**NORTHERN SYDNEY
CENTRAL COAST
NSW HEALTH**

Re: North Sydney Zone Substation Redevelopment (MP 10_0092) – Environmental Assessment Exhibition

The report entitled North Sydney 132kV Zone Substation, EMF Assessment Energy2UAlliance prepared by Aurecon Australia Pty Ltd dated 19 August 2010 provides a detailed assessment of EMFs exposures likely to occur as a result of the project. Due to the varying land uses around the site the most sensitive human receptors would be located in the proposed mixed commercial/resident building at 136-140 Walker Street on the eastern boundary of the site. Although EMF exposures are likely to be higher at other boundaries sensitive human receptors are unlikely to be exposed to significant EMFs for prolonged periods of time given the current land uses. As such comments will now be confined to the EMF exposures on the eastern boundary.

Figure 3.5 – Magnetic field profile along eastern boundary of proposed ZS

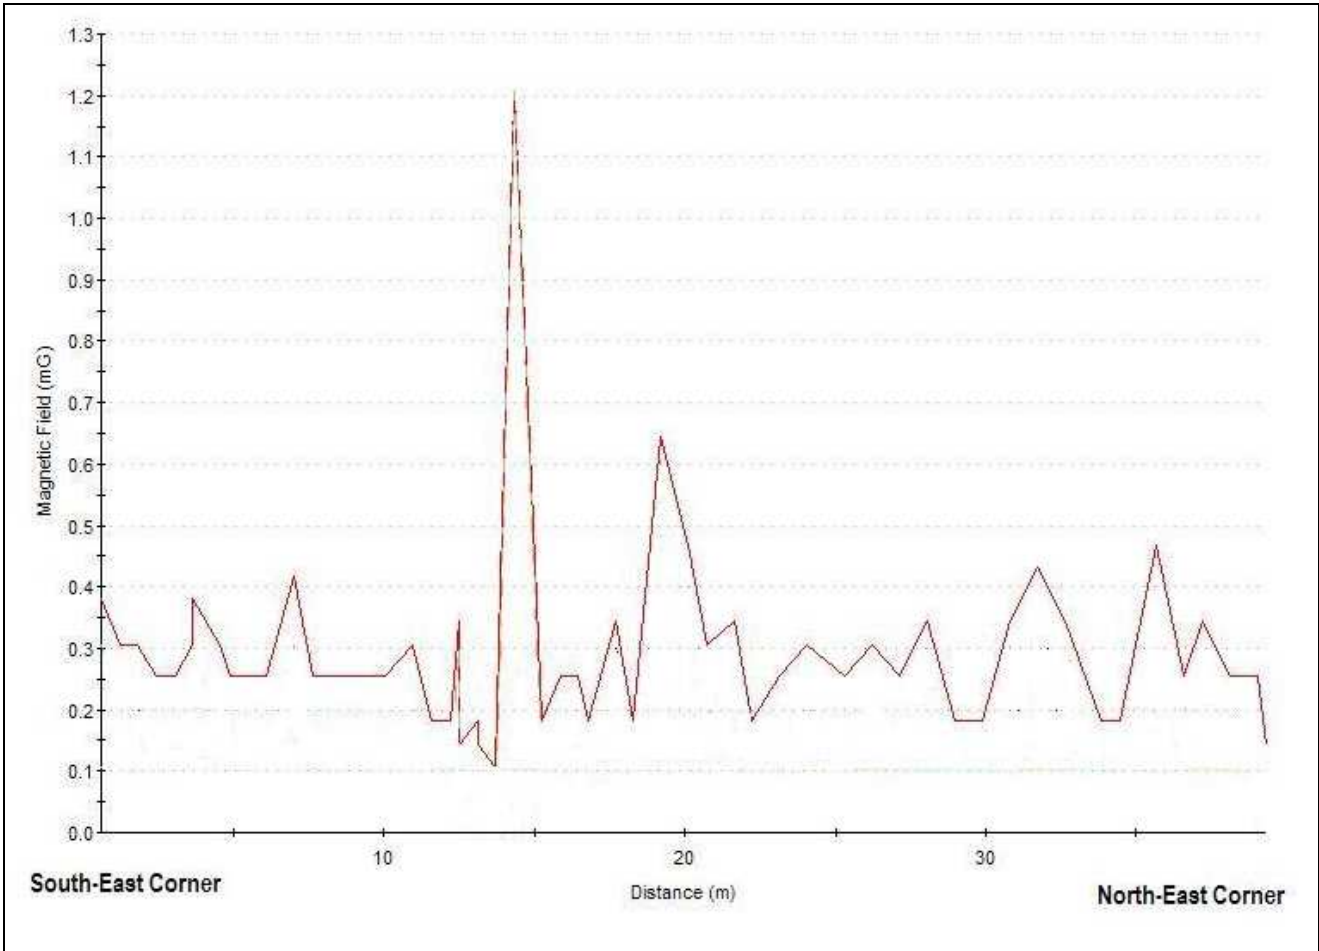
Figure 3.5 on p16 describes the current magnetic field levels along the eastern boundary with levels generally reported at about 0.3 mG. Figure 3.17 on p29 depicts the proposed substation facility in relation to the proposed commercial/residential development. It can be seen that some proposed residences will be located adjacent to the boundary of the proposed substation facility with those located on level 5 likely to have the greatest exposure to EMF from the proposed substation.

Figure 3.21 – Magnetic Field contribution at Level 5 of the proposed mixed use development (Residential)

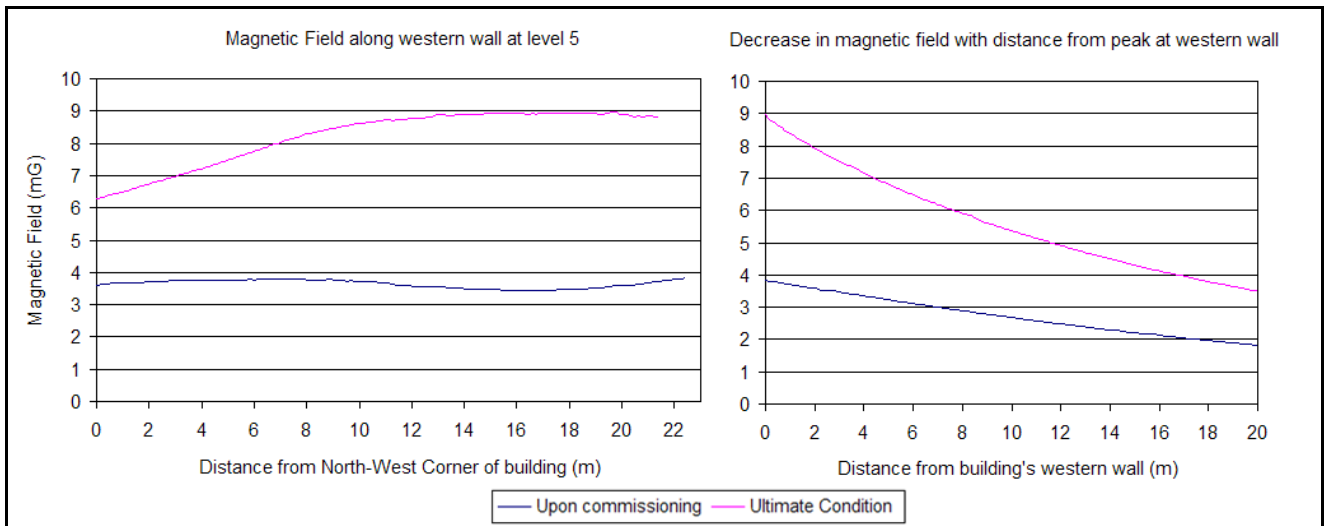
Figure 3.21 predicts that EMF levels for some residences on level 5 will be in the order of 6 to 9 mG and although these levels decrease with distance from the external wall they will still be approximately half of these levels at a distance of 10 metres from the outside wall. These levels are substantial higher than the existing levels of approximately 0.3 mG measured at the boundary.

In summary, the EA predicts that sensitive residential receptors will be exposed to a substantial increase in EMF exposure above currently existing levels if the substation facility is constructed as currently designed. It is recommended that the design of the project should be altered with the objective of reducing this predicted increase over background levels.
